## WEST SUSSEX COUNTY COUNCIL CONSULTATION

| <b>LOCATION:</b>                | 6 Selborne Road<br>Littlehampton<br>BN17 5NH                                                                                                                                                                                                                                                                                                                                                             |
| <b>SUBJECT:</b>                 | LU/163/20/PL<br><br>Demolition of existing conservatory, single storey front & rear extensions & change of use from HMO (Sui Generis) to 5 No. flats (4 net) (C3 Dwelling house). This application affects the character & appearance of the Littlehampton Seafront Conservation Area & may affect the setting of a listed building. This application is not CIL Liable as flats in Zone 4 (Zero Rated). |

Proposed Second Floor Plan 1:50

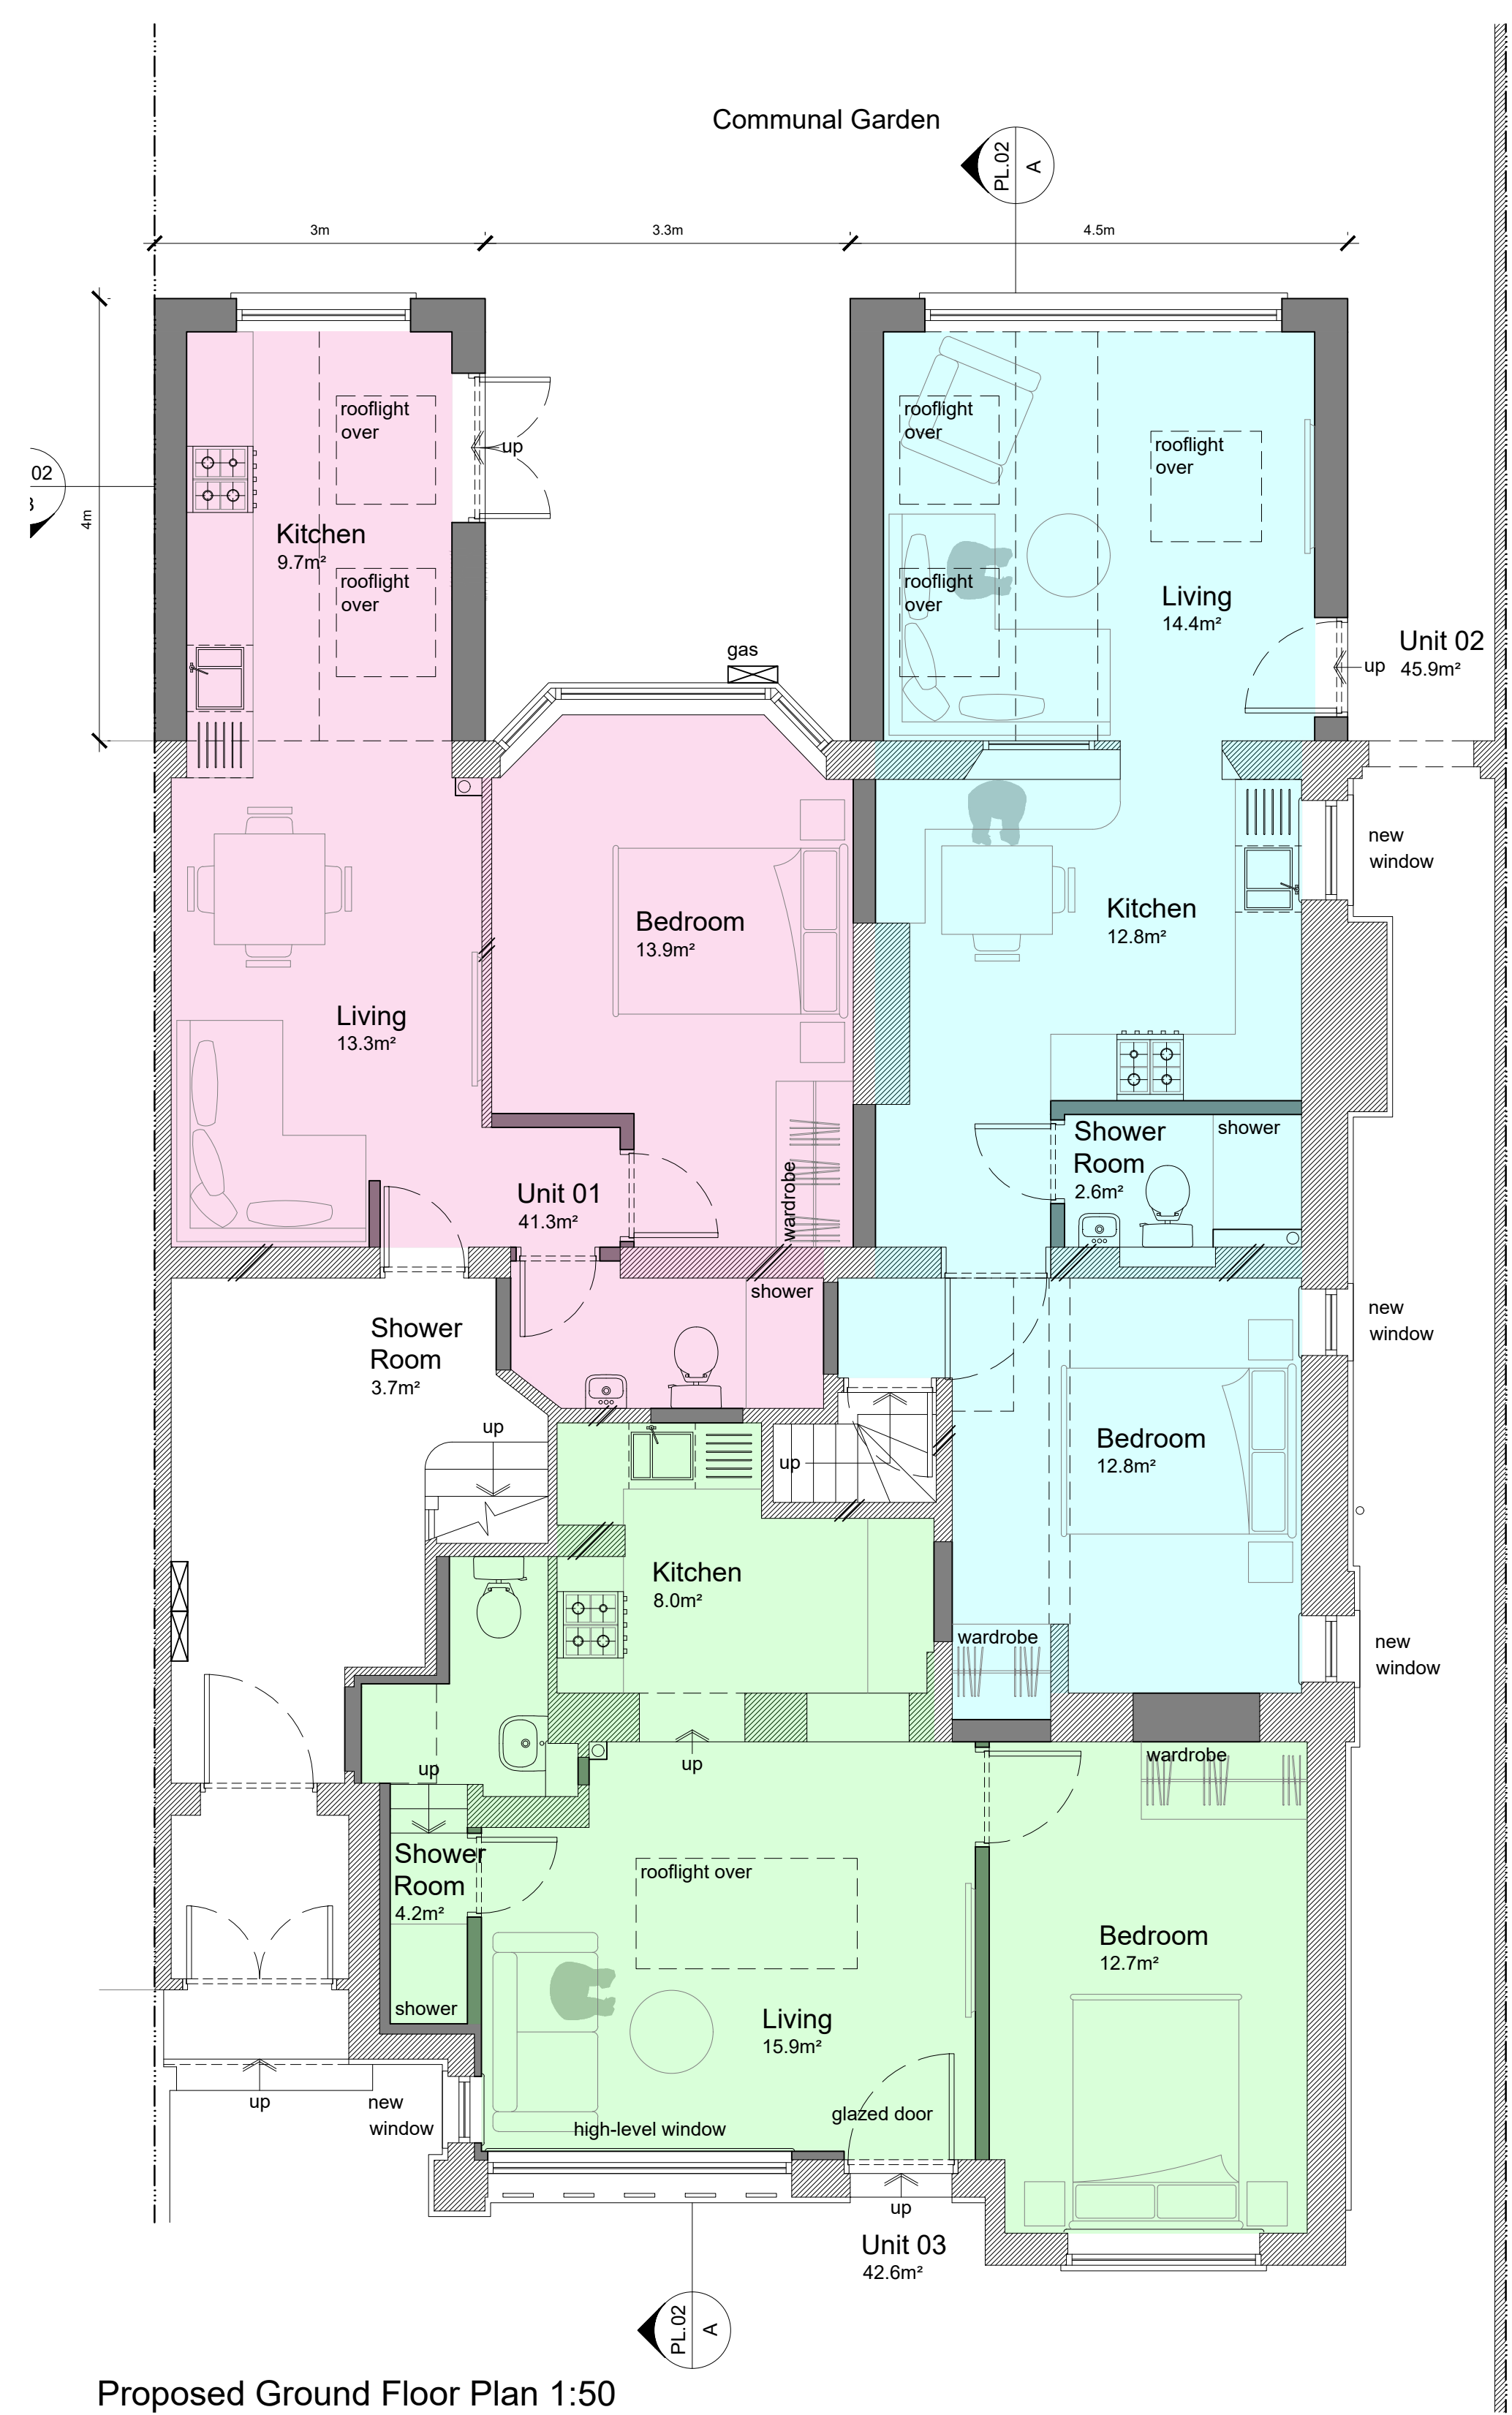
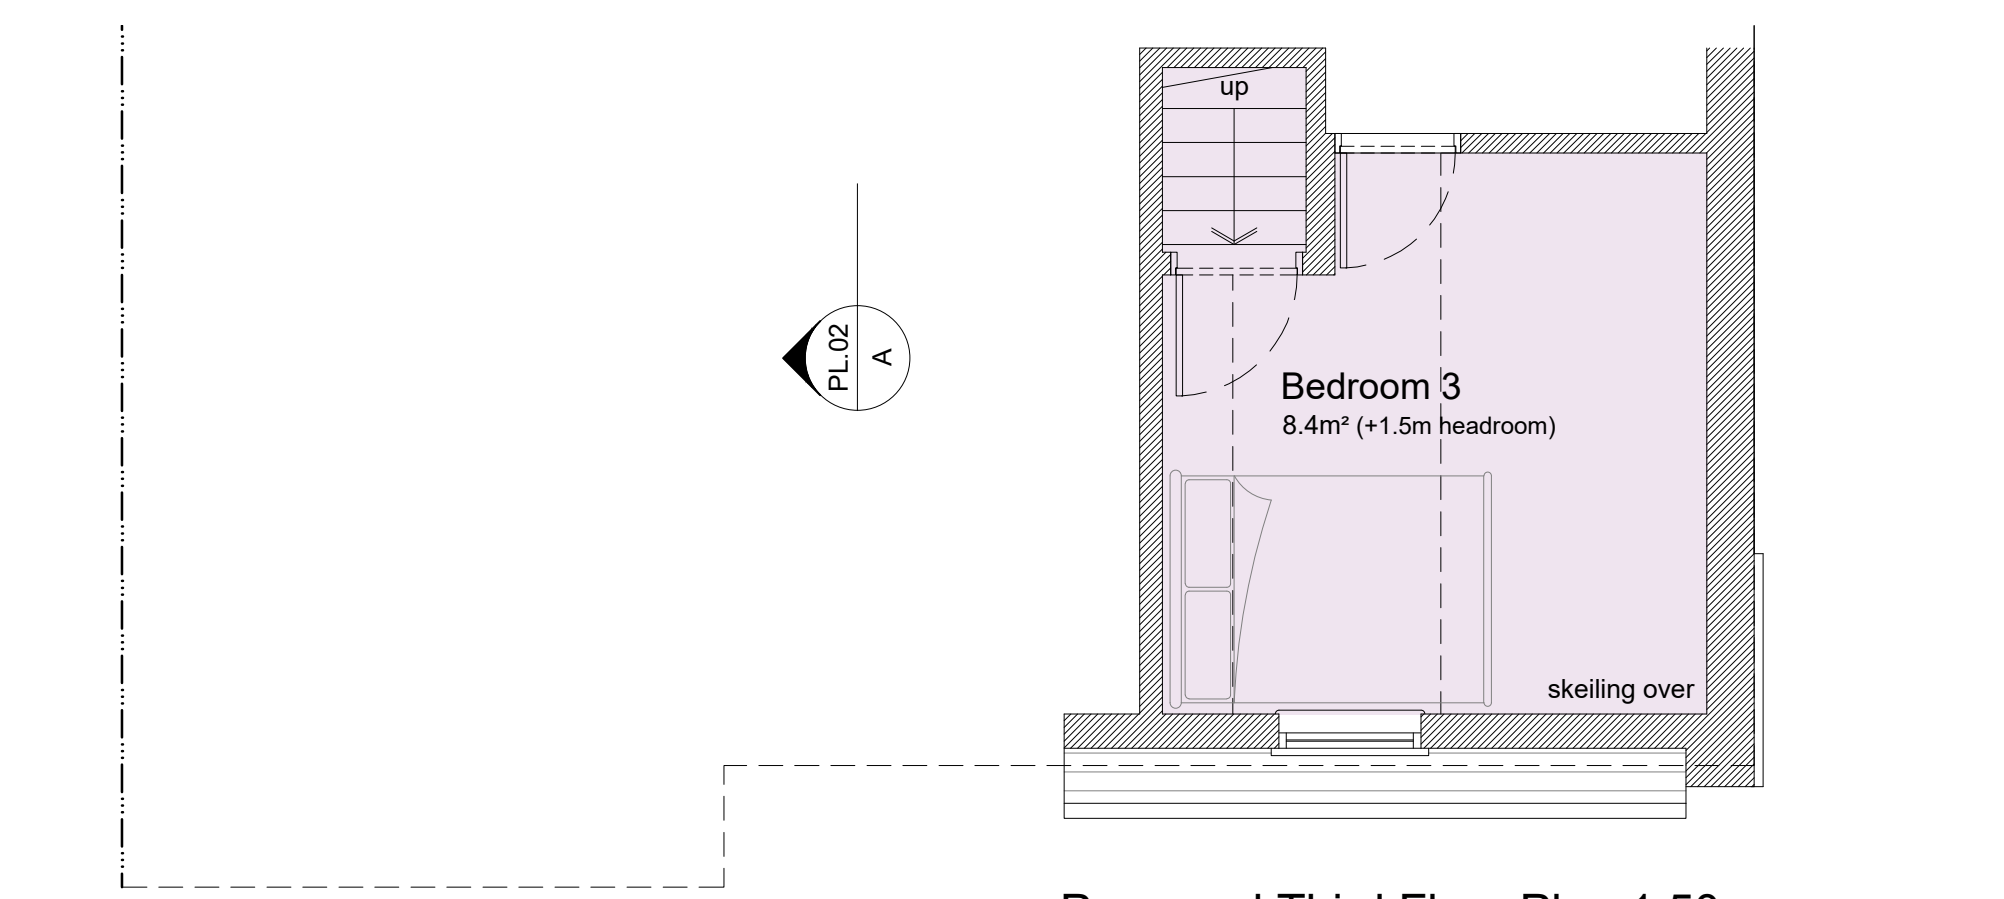
The applicant has not specifically demonstrated the existing/proposed parking provision, but it seems that the existing hardstanding parking area could likely accommodate circa 4 – 5 vehicles. I note that the proposed block plan details refuse and recycling within the existing hardstanding, it is anticipated that this could be provided in a more efficient space to retain all available on-site parking provision.

I would be minded to advise a condition securing the layout and demonstration of the parking provision so it can be secured in perpetuity, ideally on an unallocated basis. The LPA and applicant may wish to resolve this matter prior to determination.
